REF: 22/01715/OUT

**Location: Land South Of Perdiswell Farm Shipton Road
Shipton On Cherwell**

01 August 2022

SKETCH PLAN SHOWING LIGHTING ARRANGEMENT FOR TERTIARY ROADS

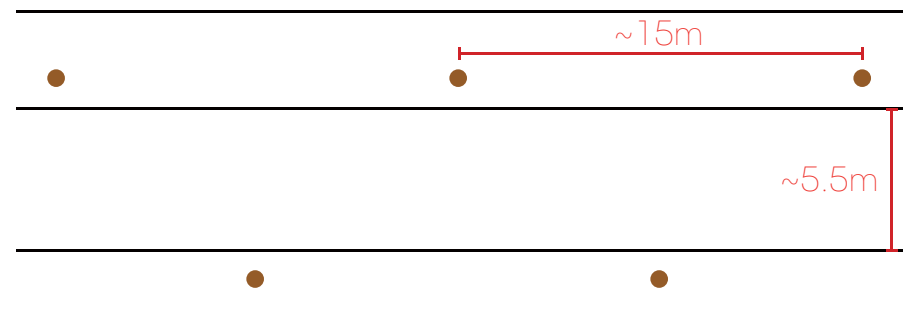
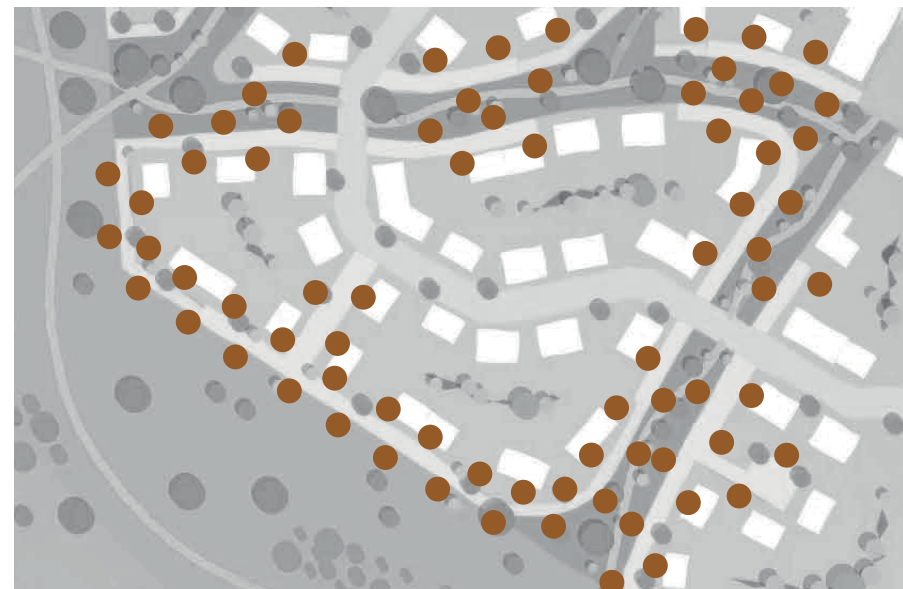
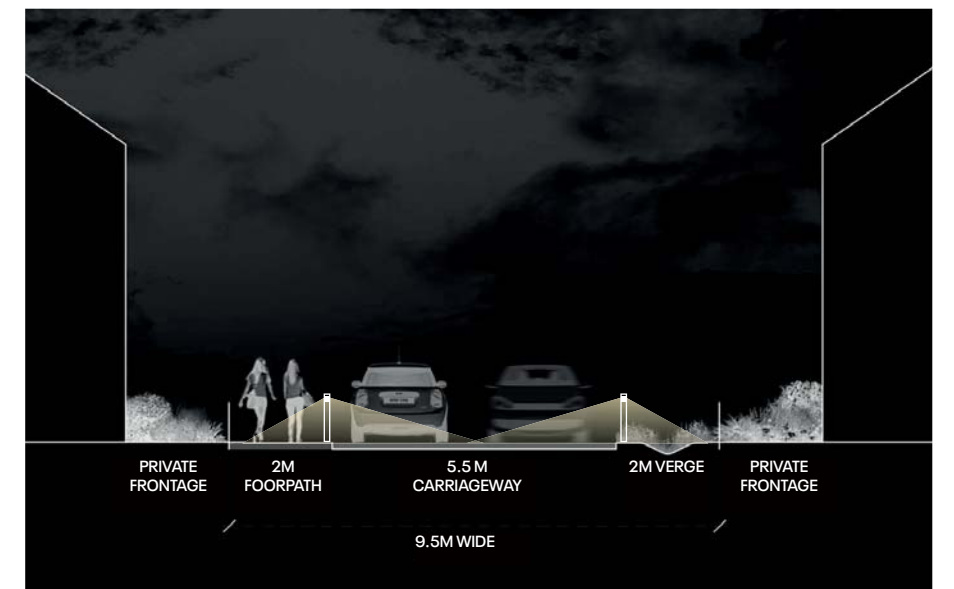
- Bollard lighting is not appropriate and must not be used, as they can be damaged by reversing vehicles and more critically they do not provide sufficient light at the right height to aid facial recognition and reduce the fear of crime. It does not deter crime and antisocial behaviour.

Lighting throughout the development should meet the general standards of BS5489-1:2020. Lighting plans should be provided which should set out how this standard will be achieved not only on adopted highways, but also un-adopted roads and parking courts. Note above, parking court lighting should be included within the plan, and be fed from the main highway. Bollard lighting is not an appropriate lighting method, and should be avoided. Not only can they be damaged by reversing vehicles, more critically they do not provide sufficient light at the right height to aid facial recognition and reduce the fear of crime. It also does not deter crime and antisocial behaviour.
